Planning Application Ref: FG/162/17/PL (3) Current comments in blue typeface

Location: 1 Upper West Drive, Ferring

Description of works: Demolition of existing detached garage & erection of 1 No dwelling

EXISTING SITE PLAN 1:100

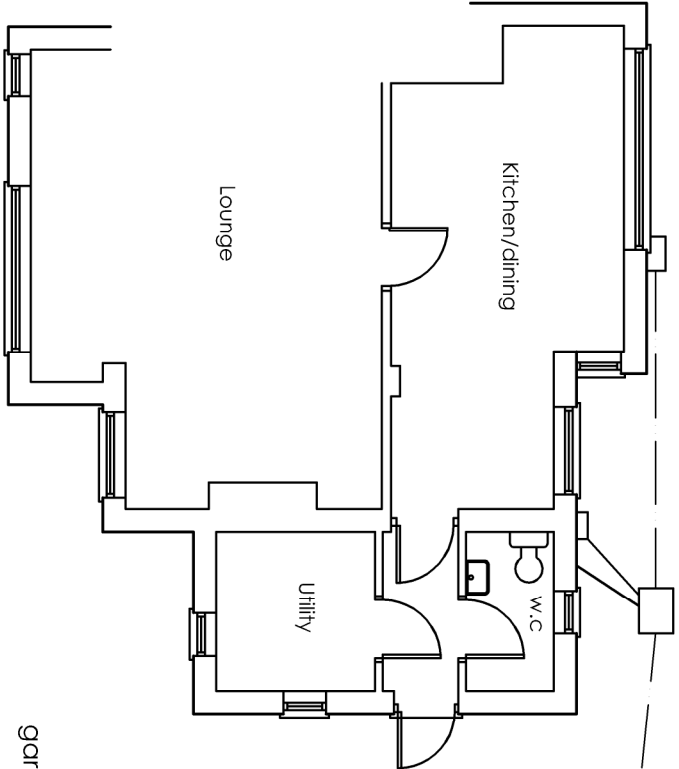
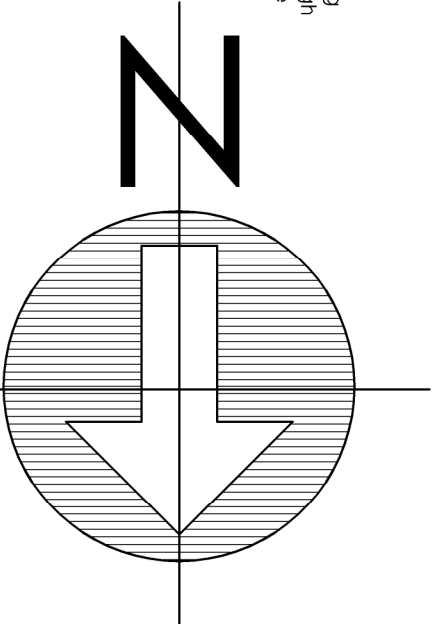
- There is a very fine specimen of a mature Sycamore in the verge outside which is the subject of a TPO.
- Some details have been provided but by an Architect and not an Arboricultural Expert hence there is no AMS & Tree Protection Plan nor a Method Statement & Tree Protection Plan submitted in support of this application.

- The footprint of the new building will be well within the Root Protection Area of this tree and will therefore require to be justified and the impacts of any root damage mitigated.

PROPOSED GROUND FLOOR PLAN 1:100

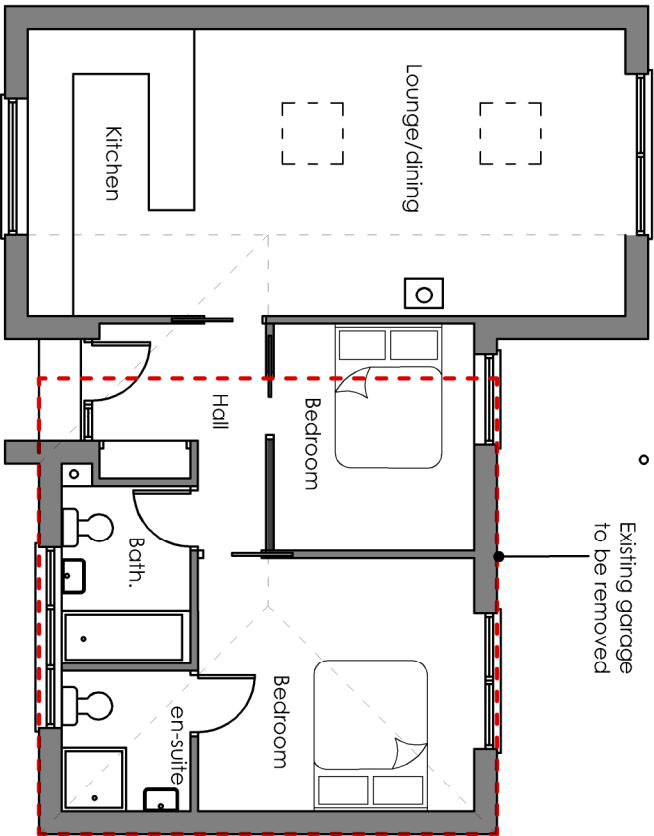
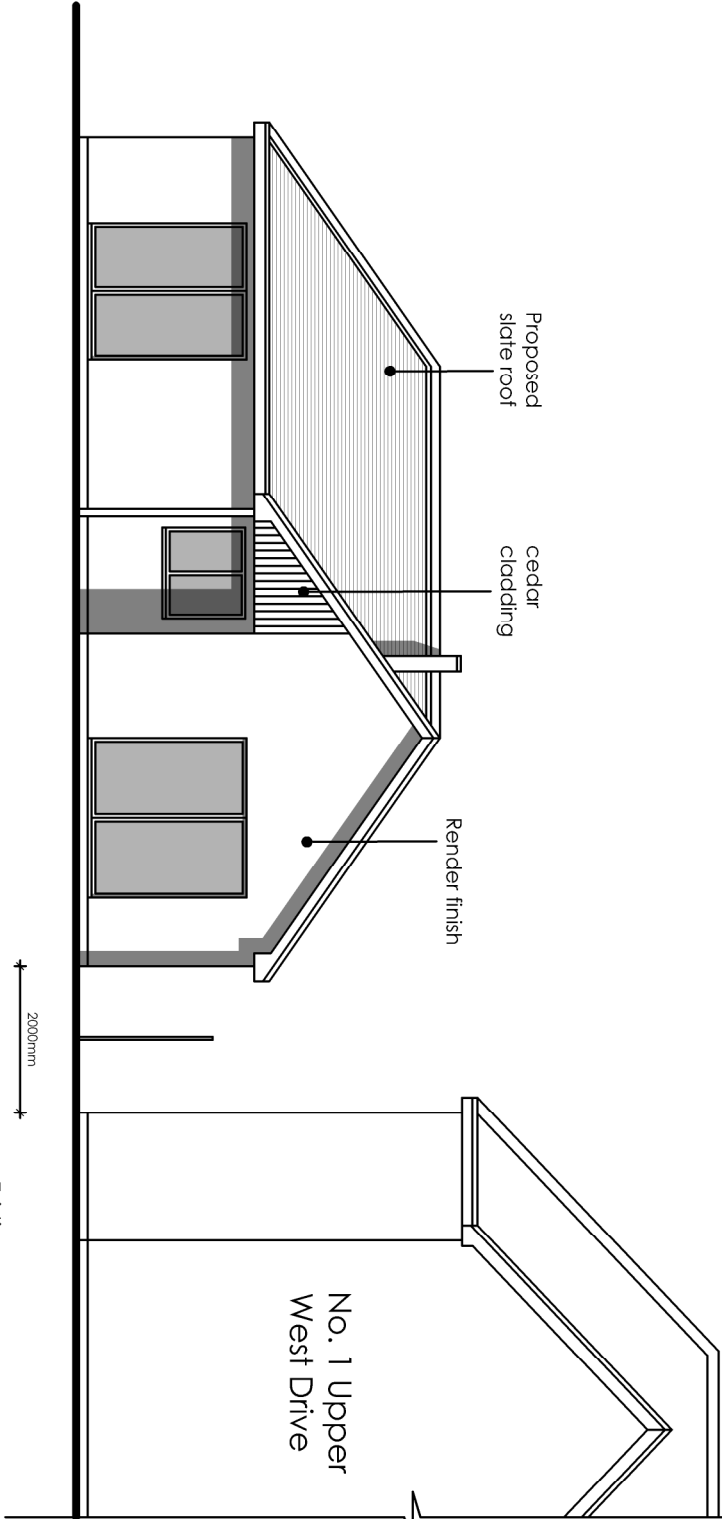
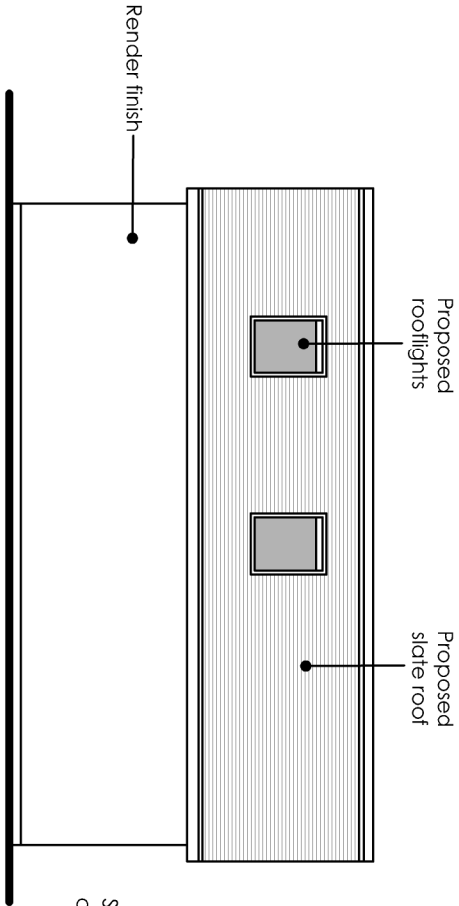
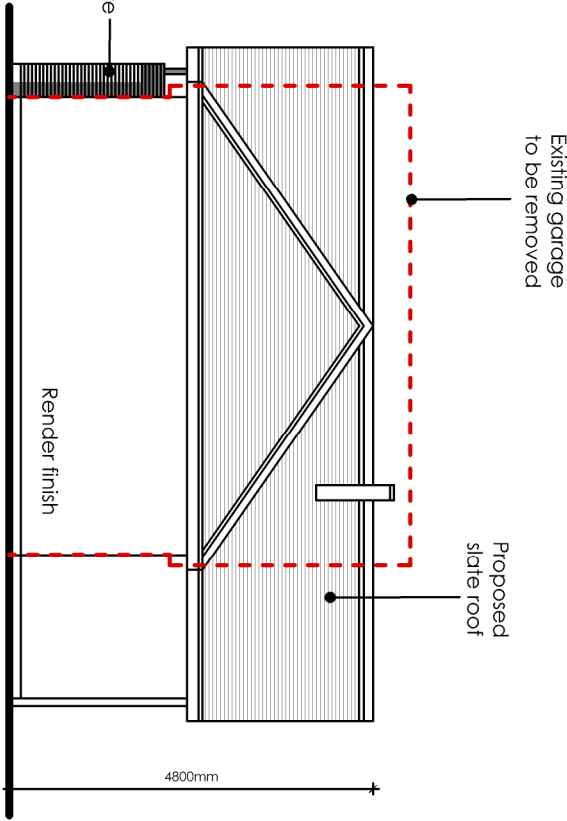
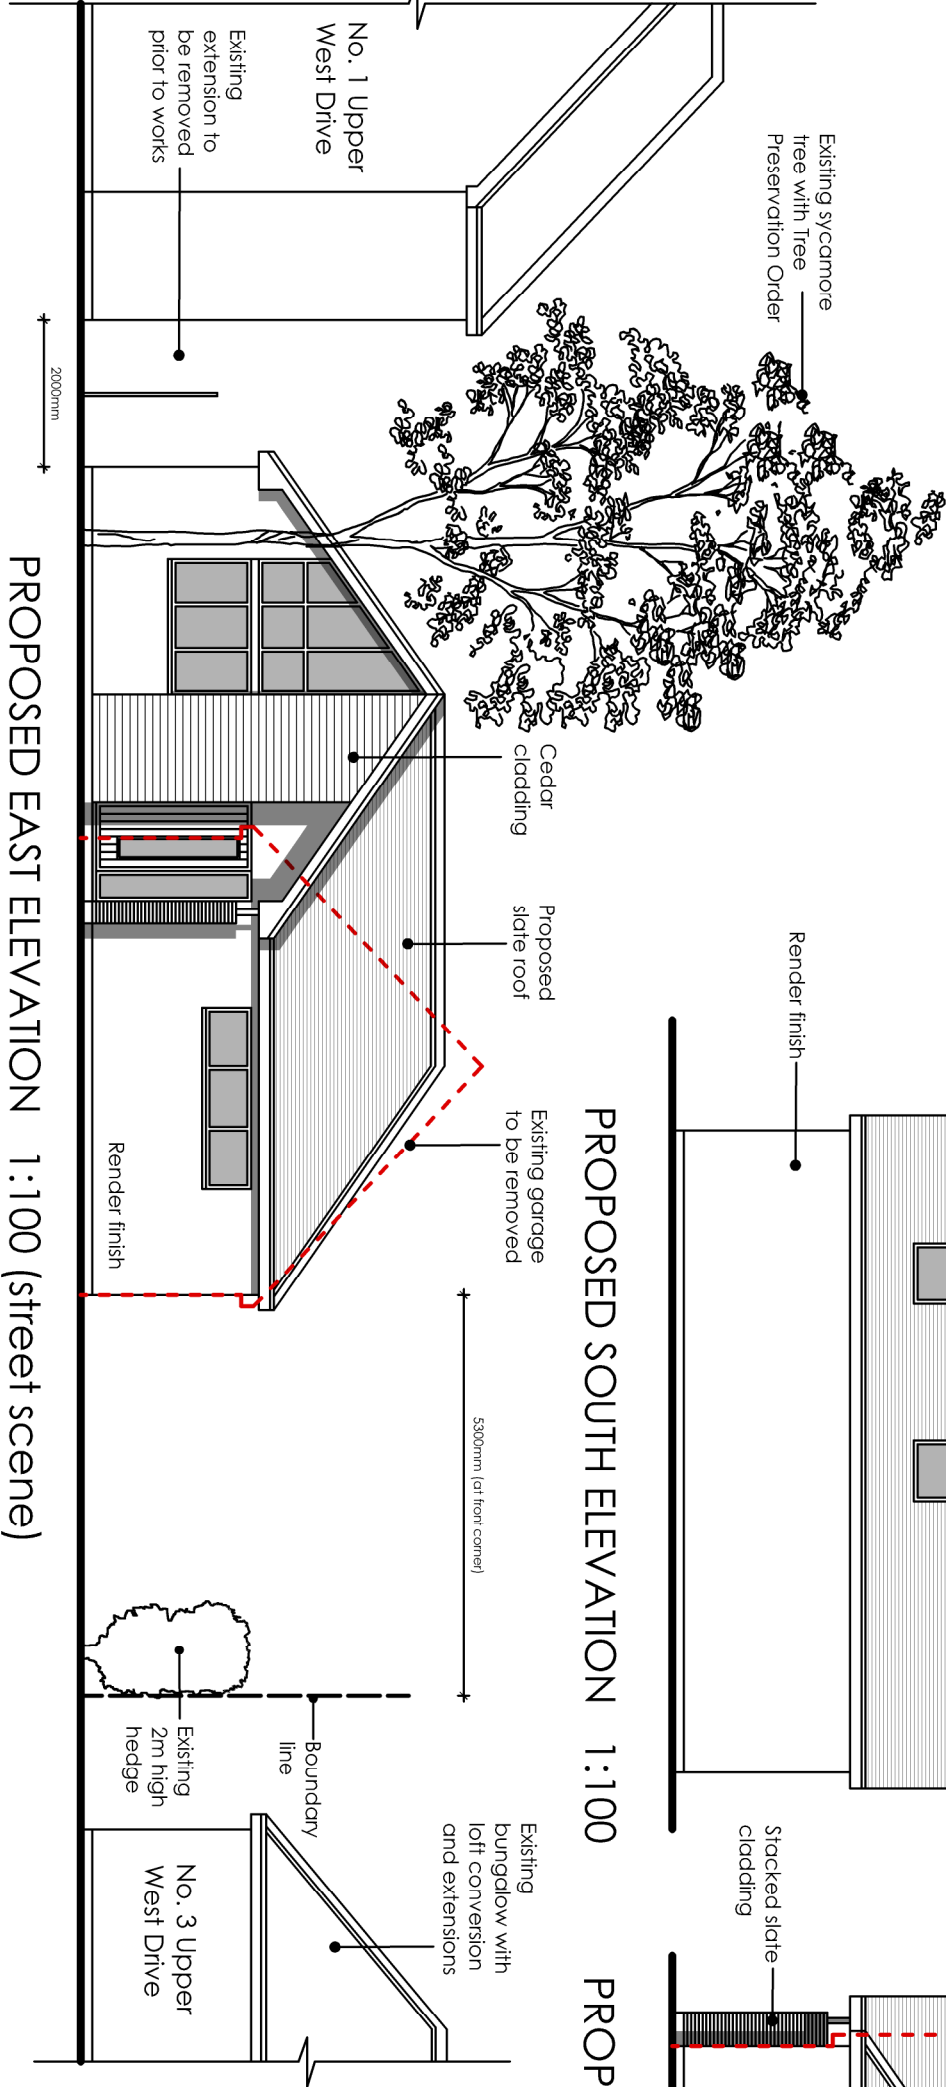
- Pile & Beam foundations might well prove to be a way of minimising the impact of development on tree roots BUT I see no evidence of cross section drawings having been submitted to show the existing and proposed levels to prove that this technique is suitable here and that a 'No Dig' solution can be applied with an above ground formed pile cap and supporting ground beams.

- I also accept that a bungalow is a better option than a two storey standard dwelling but there remains the issue of the size and imposing presence of this tree that will dwarf the bungalow. They say they have allowed for this in the design but it does not get away from the fact that as soon as someone moves in they will want the tree 'Pruned or Felled' and despite the TPO cover we will be on the back foot as far as refusing consent is concerned as we allowed the development to proceed – in my view if this went to Appeal under the TPO we would lose!

- There is also the issue of having a new building within close proximity to the crown of a large mature tree where light restriction to habitable rooms is bound to be a factor. It is highly likely that there would be 'pressure to prune or fell' if this layout were approved.

1 Upper West Drive, Ferring
Tree Protection Plan

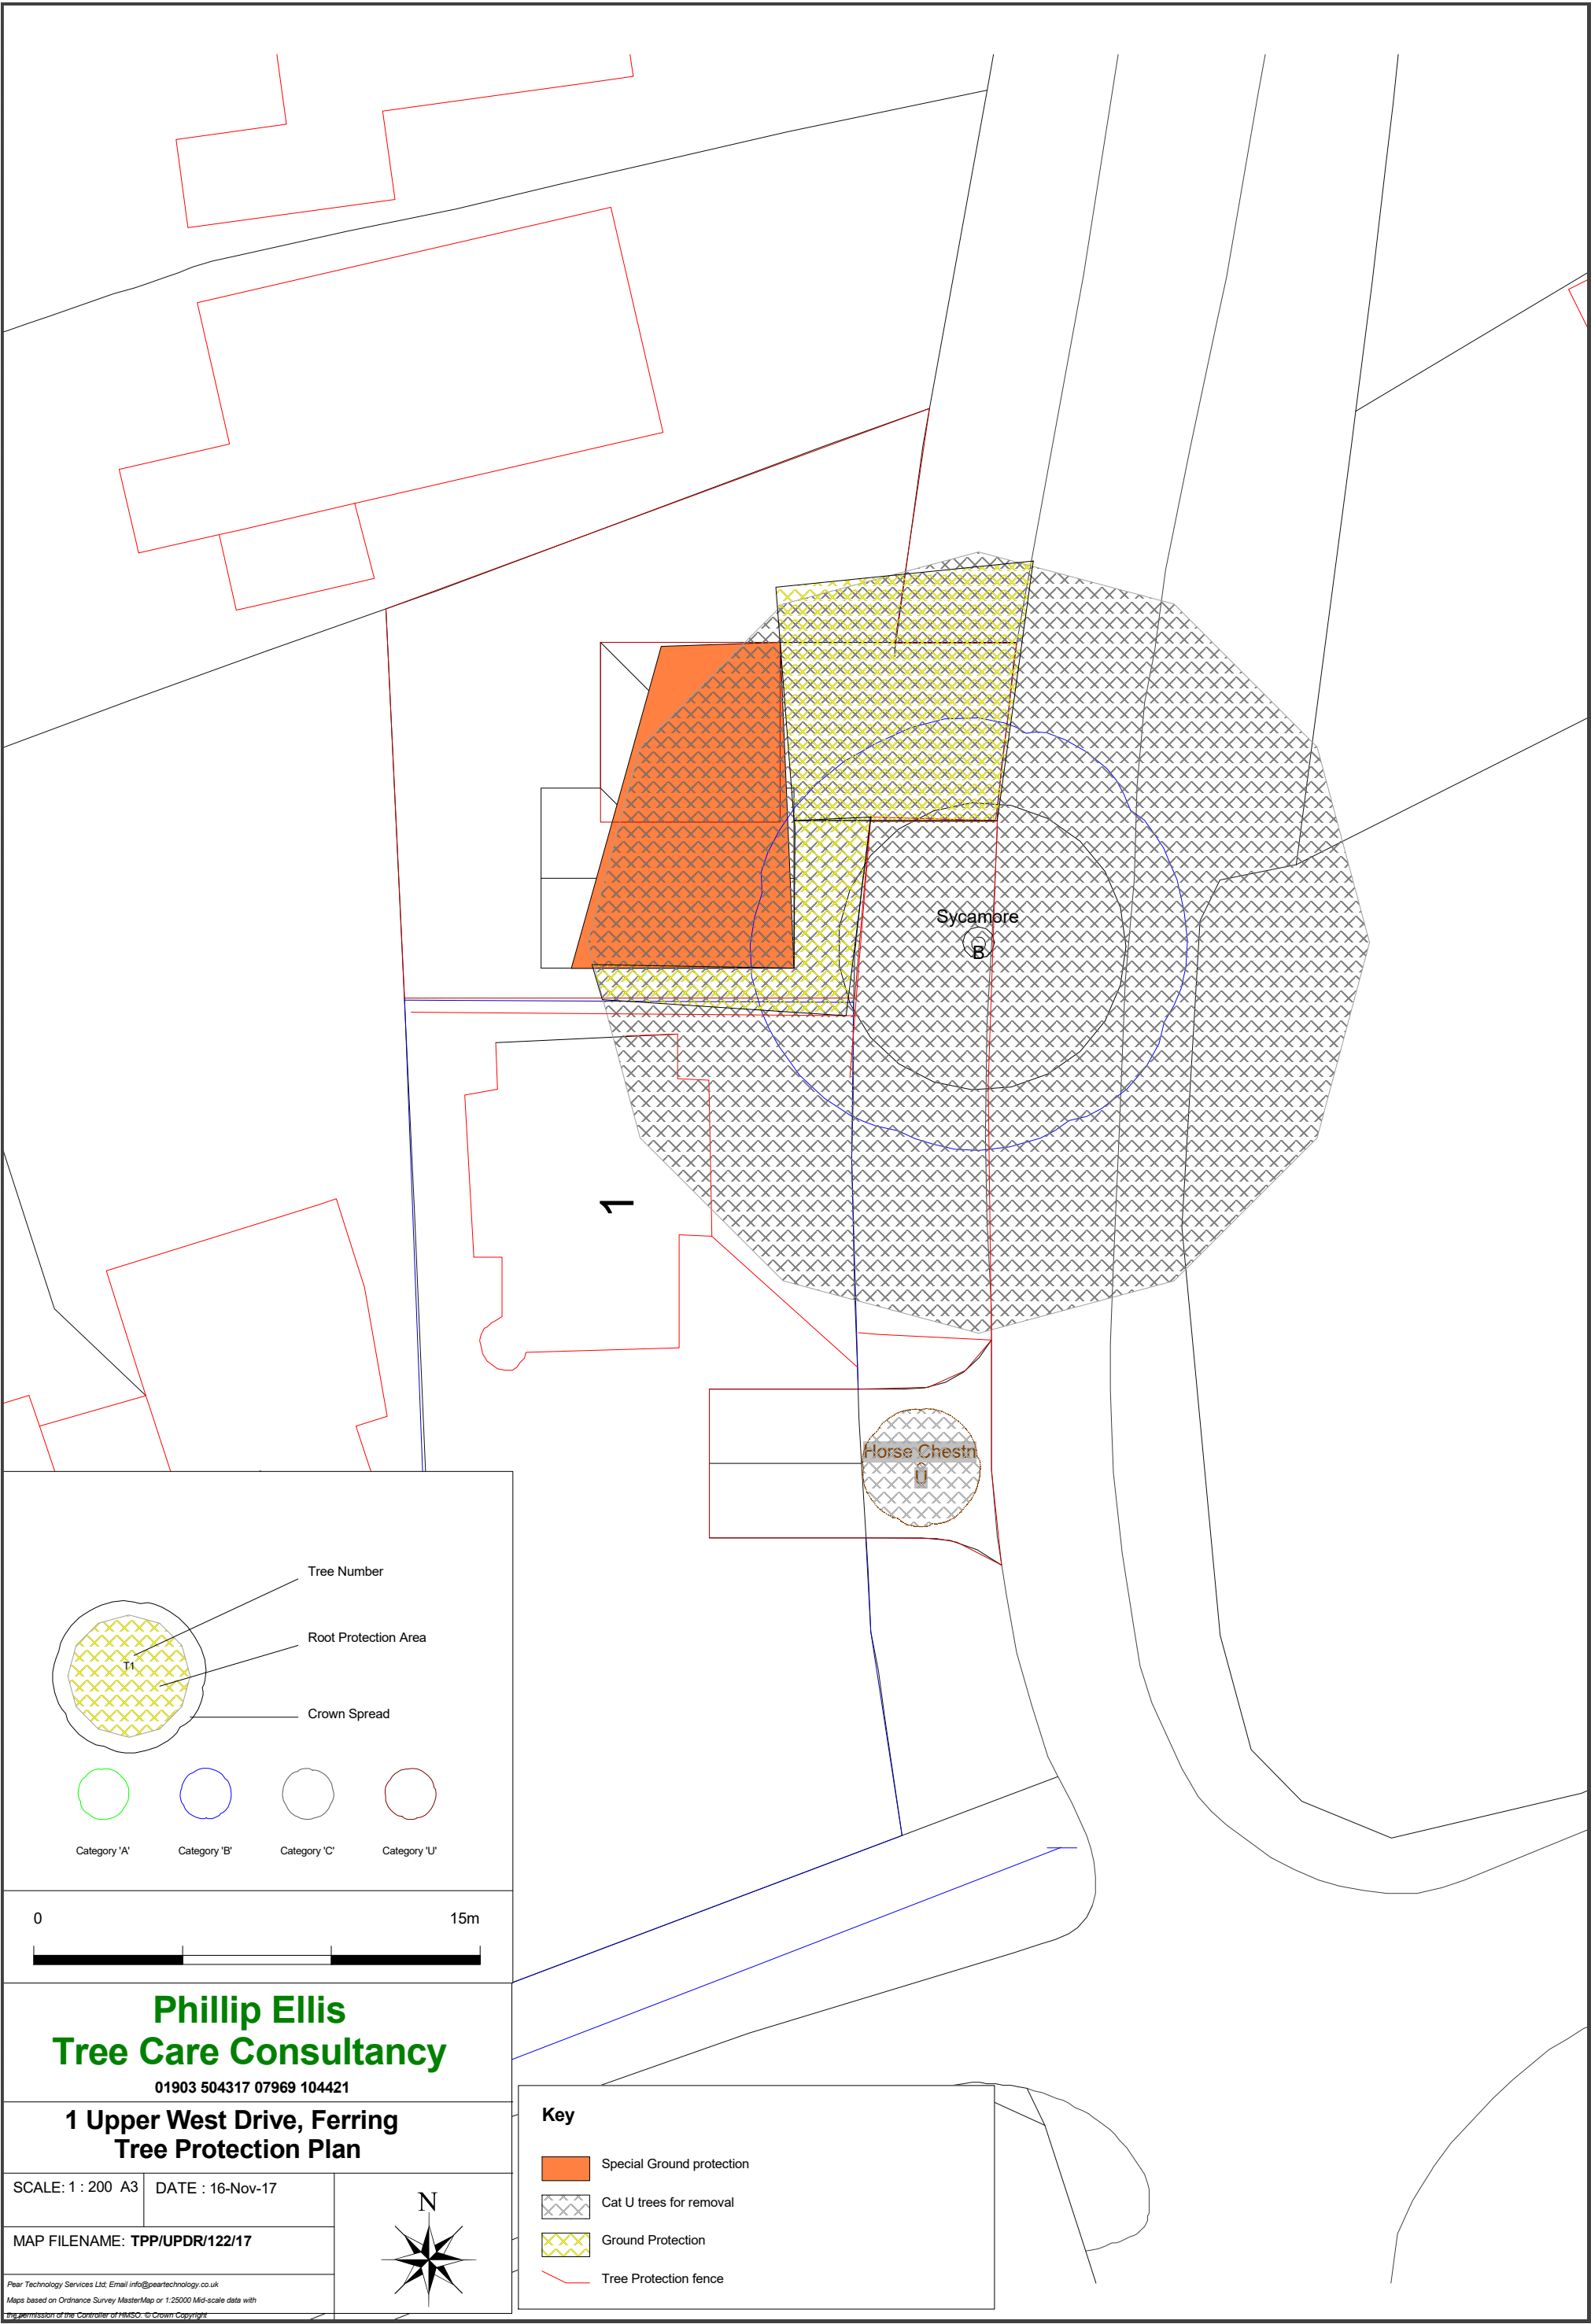
- At 6.1 it says undertake pruning works if recommended – I see nowhere that it states that pruning is required and yet the plan clearly shows the branches overhanging the footprint of the existing garage and the new building that is proposed. How are they going to erect scaffolding and construct this building without pruning back the canopy. This brings into play another factor in that no sunlight and shading data has been provided and no mention made of same in the report and yet the tree will be hard up against the building line on the east side of same? This brings into play yet another issue for me in that if this tree has to be pruned to even build the property let alone keep it clear of same in the future then this is 'pressure to prune or fell' and confirms my fears in this respect.

- However, one key element is missing in that the protective fencing is shown to be hard up against the new building and in this position it would hinder the construction process.

- If they are convinced that they can make do with just the existing drive to work from then fine – this will also need to be described in the AMS and shown on the Tree Protection Plan.
